**Consultation Response from KC,  
Highways Development Management**

**2020/91278 75, Briarlyn Road, Birchcliffe, Huddersfield, HD3 3NW**

**Erection of two storey extension to side and rear and single storey rear extension**

PROPOSED SITE PLAN 1:200

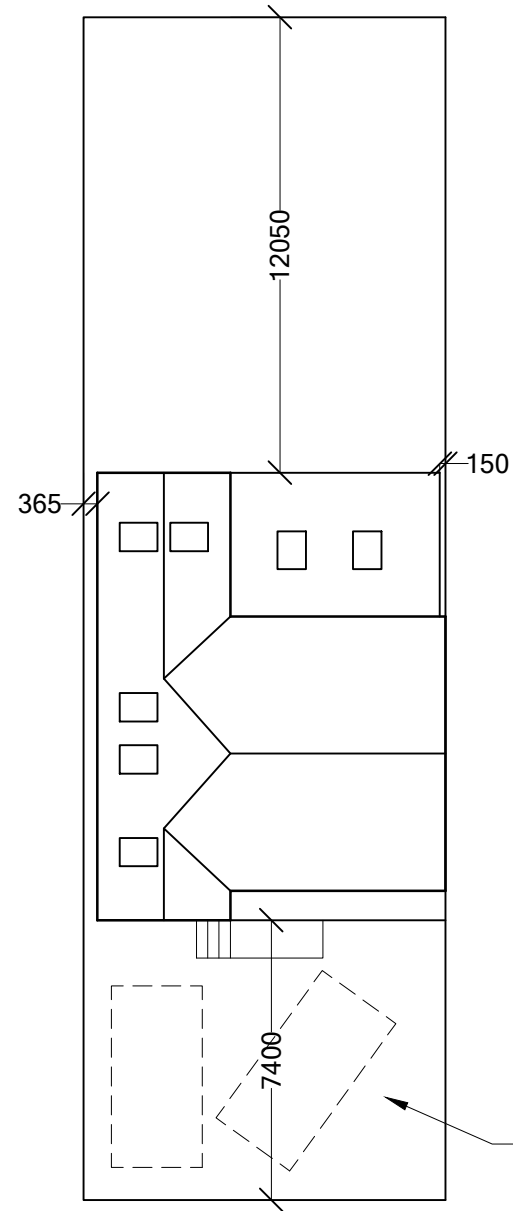
This proposal is to demolish the existing garage and build the two-storey extension on existing driveway to the side of the existing house in order to create a 5 bedroomed house.

Two existing off-street parking spaces are shown to be retained to the site frontage and Highways Development Management have therefore no objection to these proposals.
